# CITY OF ALBUQUERQUE

**Planning Department  
Transportation Development Services Section**

Re: Certification Submittal for Final Building Certificate of Occupancy for  
Dion's Resturant NM#5, [L-21/D069]  
11000 Central SE  
Engineer's Stamp Dated 06/16/09

The TCL / Letter of Certification submitted on June 16, 2009 is sufficient for acceptance by this office for final Certificate of Occupancy (C.O.). Notification has been made to the Building and Safety Section.

A TRASH ENCLOSURE
SCALE: 1" = 10'

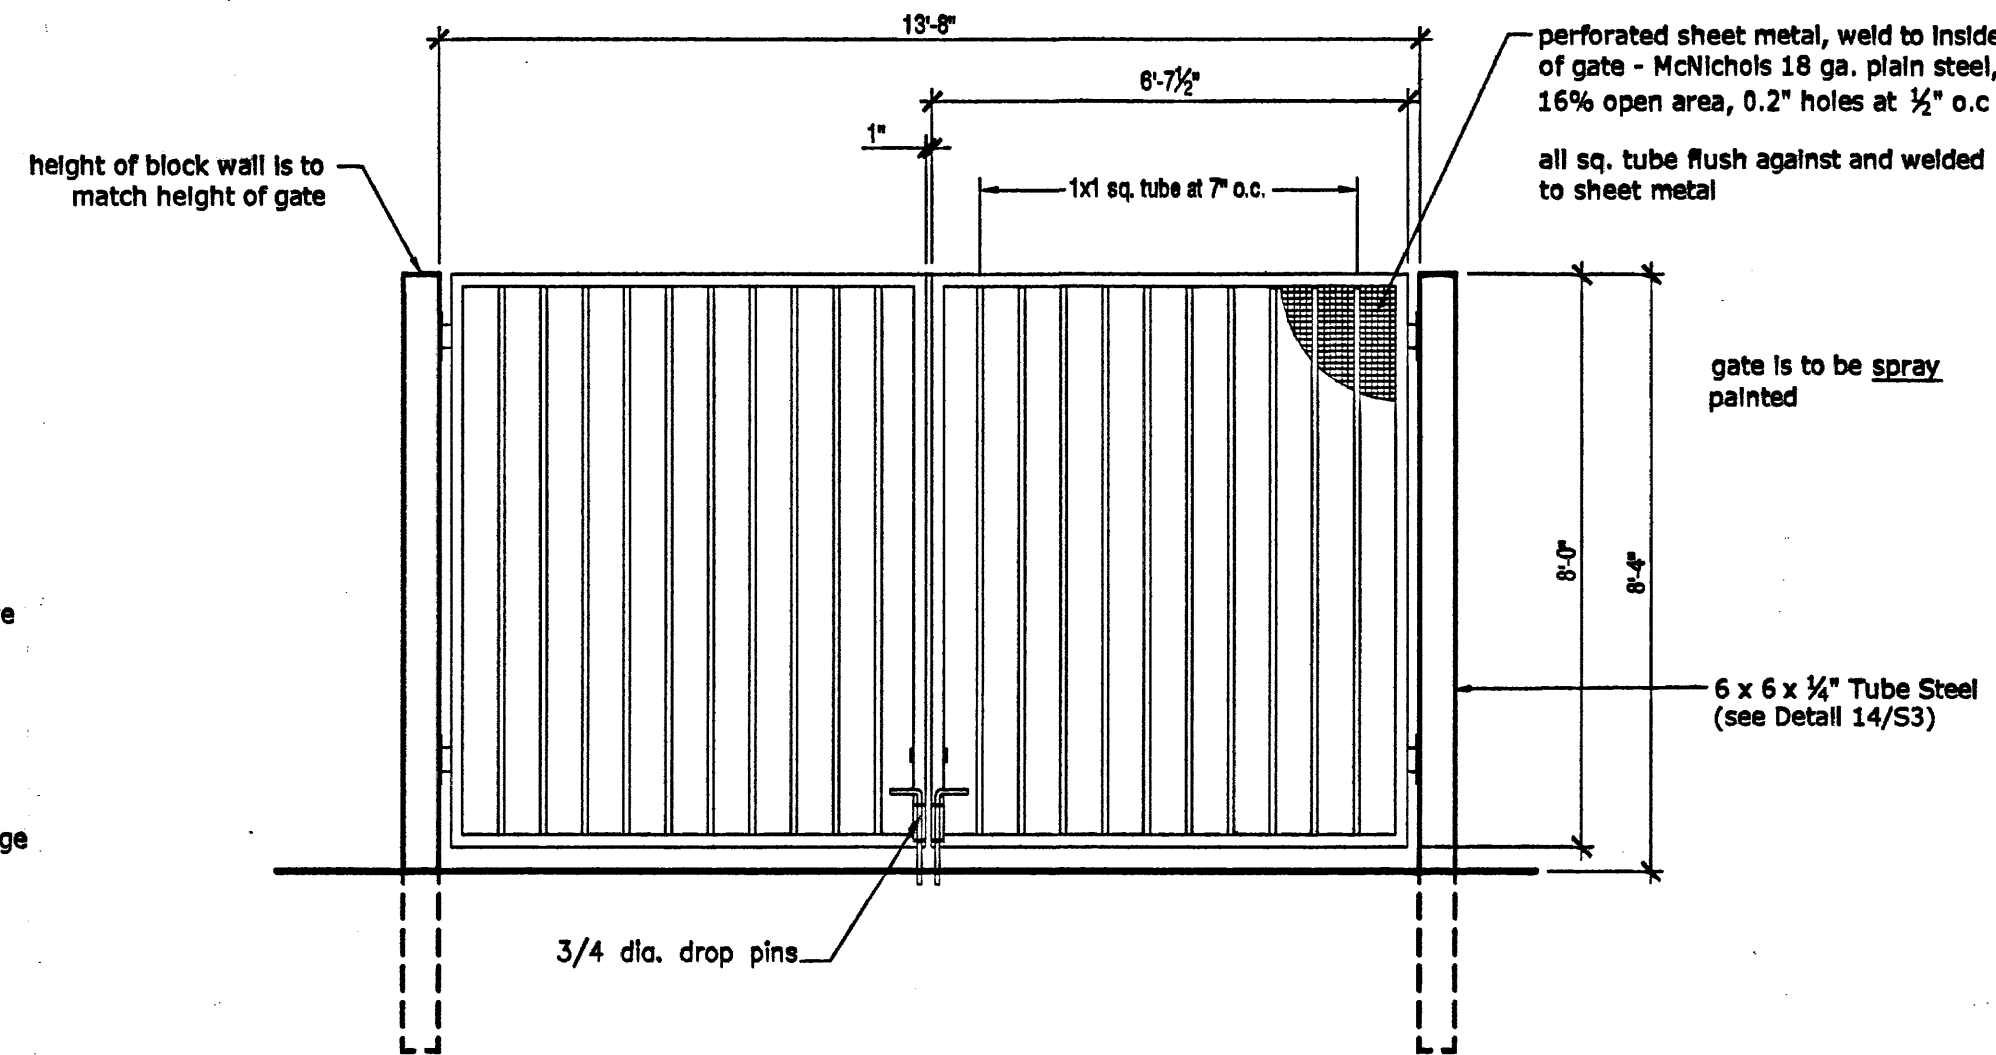
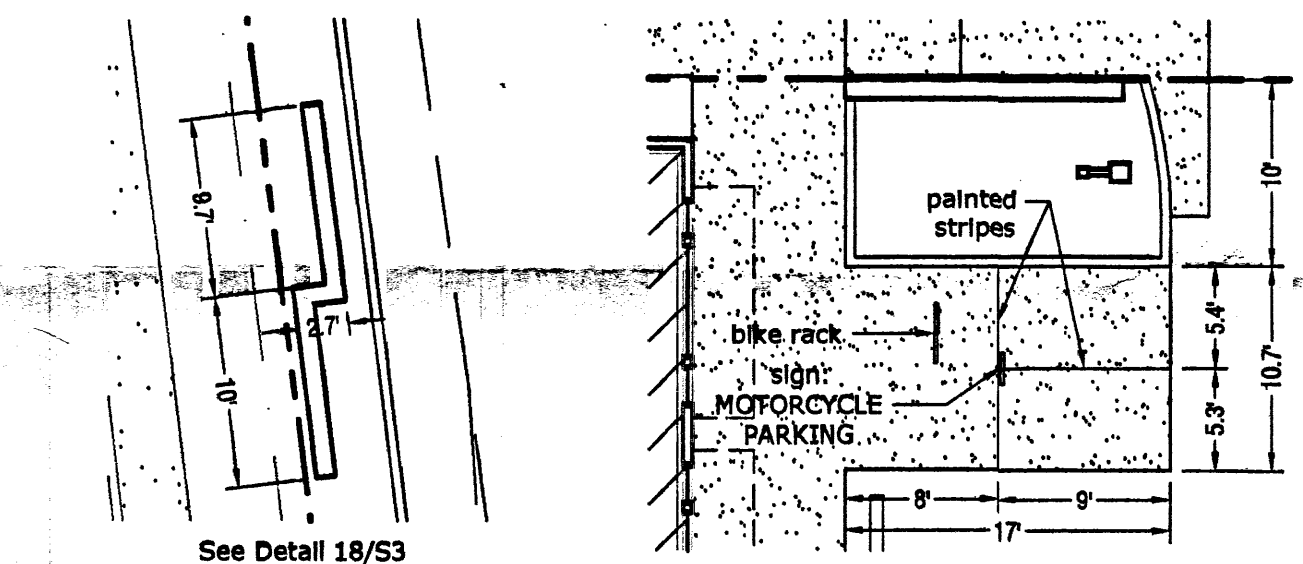
2. Per the DPM Chapter 22 Sect-9, runoff from the trash enclosure pad at a restaurant is required to drain to the sanitary sewer after passing through a grease trap. Please include details or at least refer to this plumbing which may be shown on another sheet.

1. SWPPP is required for construction grading on this site and will be provided by contractor prior to receiving grading or building permit.
2. Note added to plan identifying drain inlet to capture runoff from the trash enclosure pad for routing to sanitary sewer after passing through a grease trap.
3. Additional proposed grades provided within private landscaped areas along Elizabeth Street to clearly identify direction of flow to proposed storm drain inlets. Additional inlet provided in the landscaped area NW of the building pad to ensure that roof drain flows are not routed over the sidewalk.
4. Building FF elevations clarified with approximate location of level change.

Sheet Title:
ARCHITECTURAL
SITE PLAN

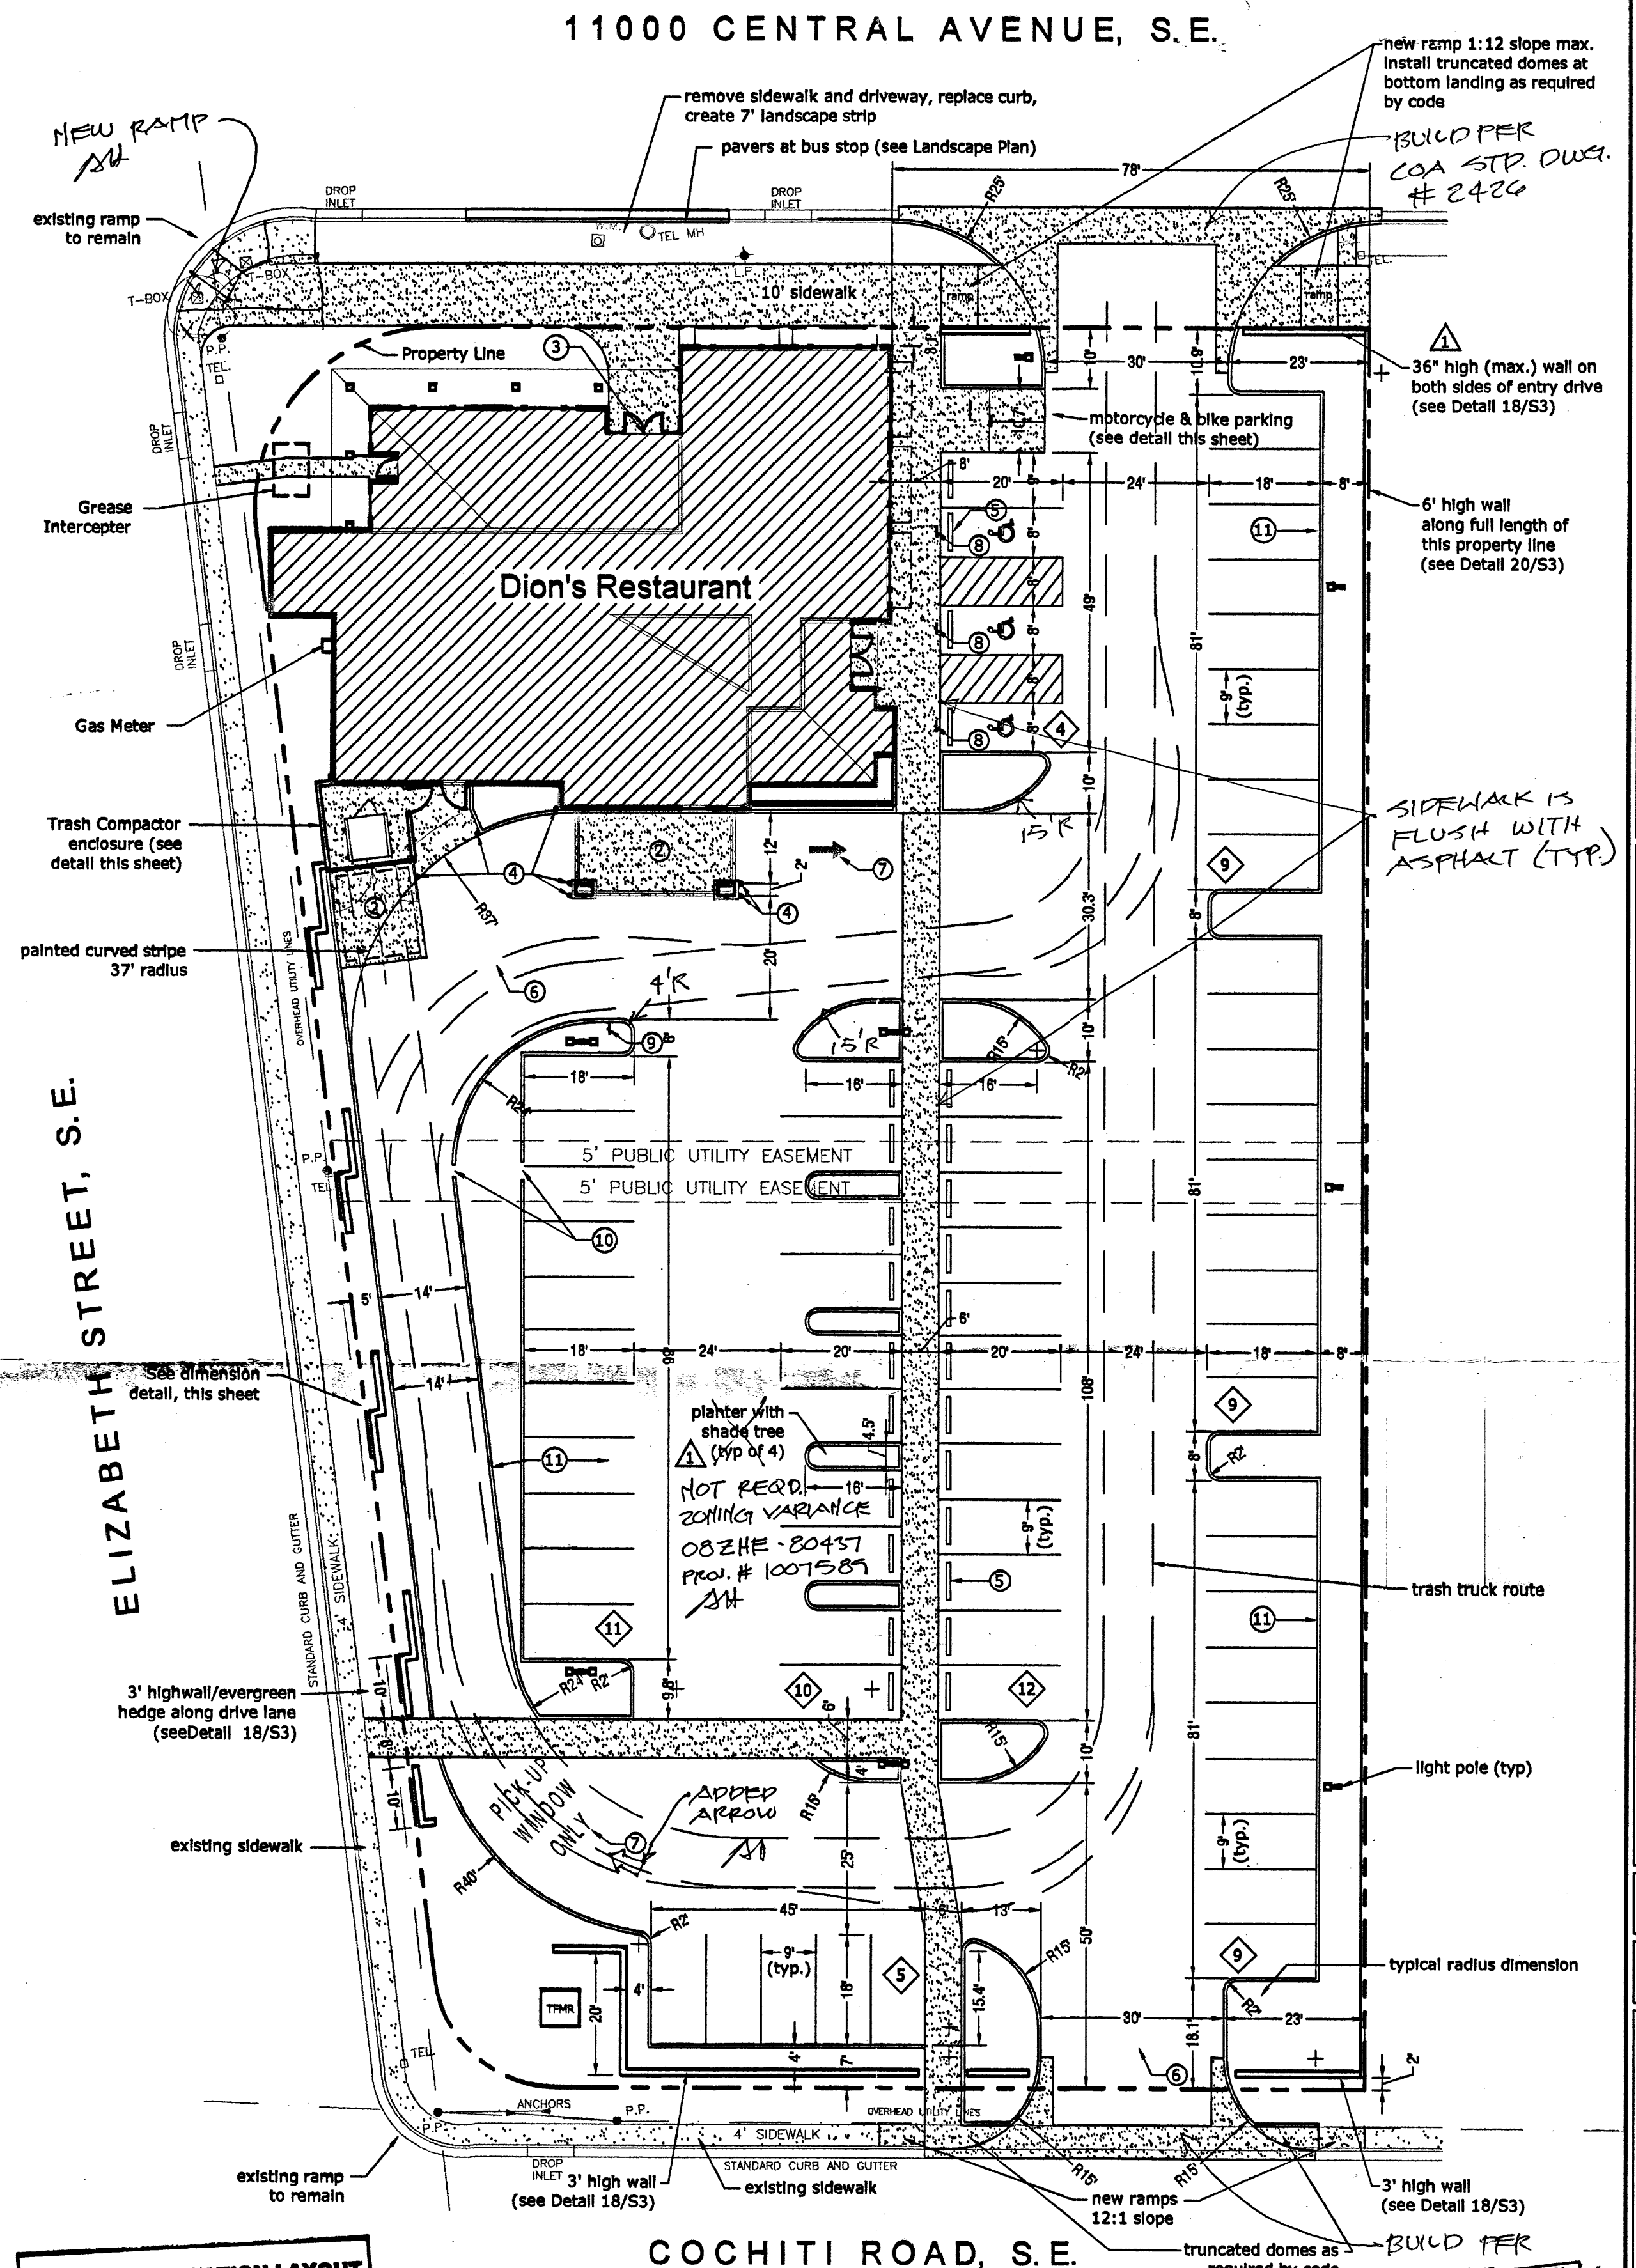
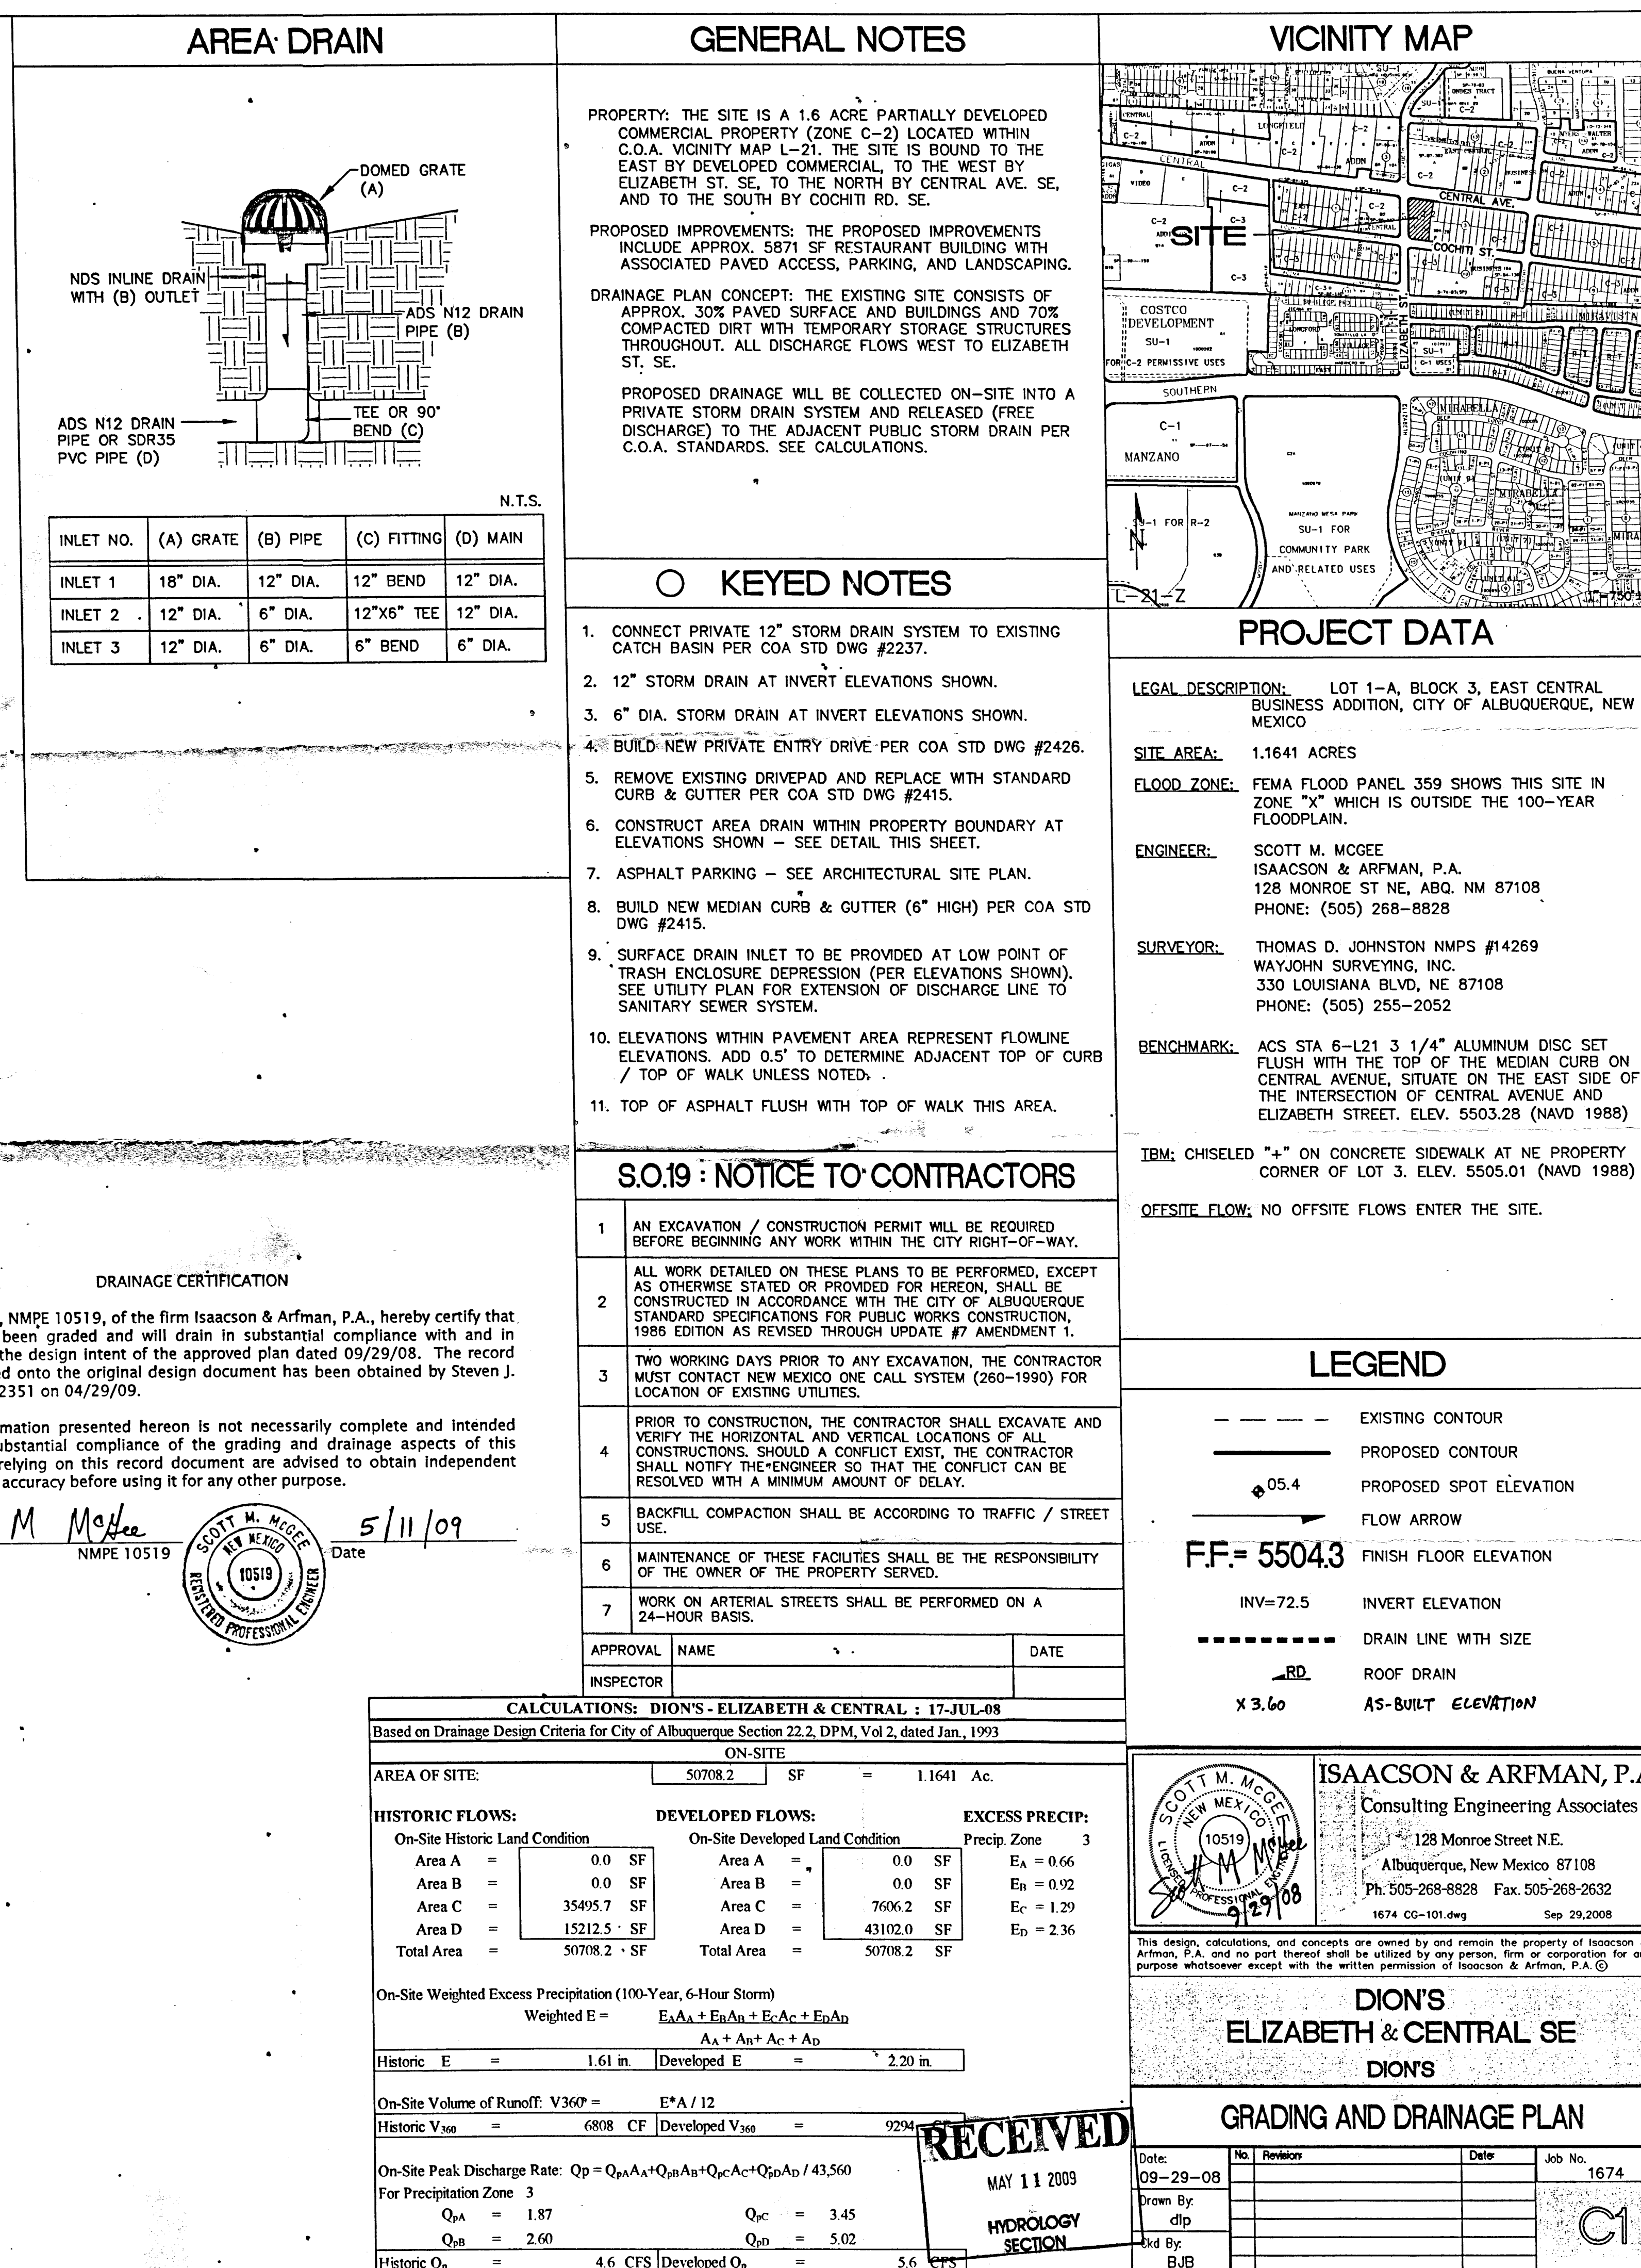
A Temporary C.O. has been issued allowing the outstanding Approved Site (need to provide the approved site plan dated 10/23/08), Central Ave. Infrastructure (entrance eastern ramp and sidewalk connection will need to be 5' in width; wheel ramp at the corner of Elizabeth St. is not ADA; and cracked sidewalk adjacent to ramp will need to be replaced), missing pavers for bus stop need to be in place, and drive thru pavement markings (will need a pavement directional arrow prior to pavement markings) issues to be completed within this time period. When these remaining issues have been fully completed, are in substantial compliance, and a final Certification for Transportation has been resubmitted to the City's Hydrology office for approval, a Permanent C.O. will be issued.

1. List radii for all curves shown.
2. For passenger vehicles, the minimum end island radius is 15 feet.
3. Build notes are needed for the proposed curb cuts. Please refer to all applicable city standards.
4. Please ensure all ramps are ADA compliant.
5. Is there a median break along Central Avenue at the site? If the site has left turn access, the drivepad has a 36-foot minimum width.
6. Is the sidewalk along the building flush with the pavement?

Call out all radii

15' min R

Need Build notes for proposed entrances  
- refer to CoA Std 2426

Entrance off Central - median  
access?
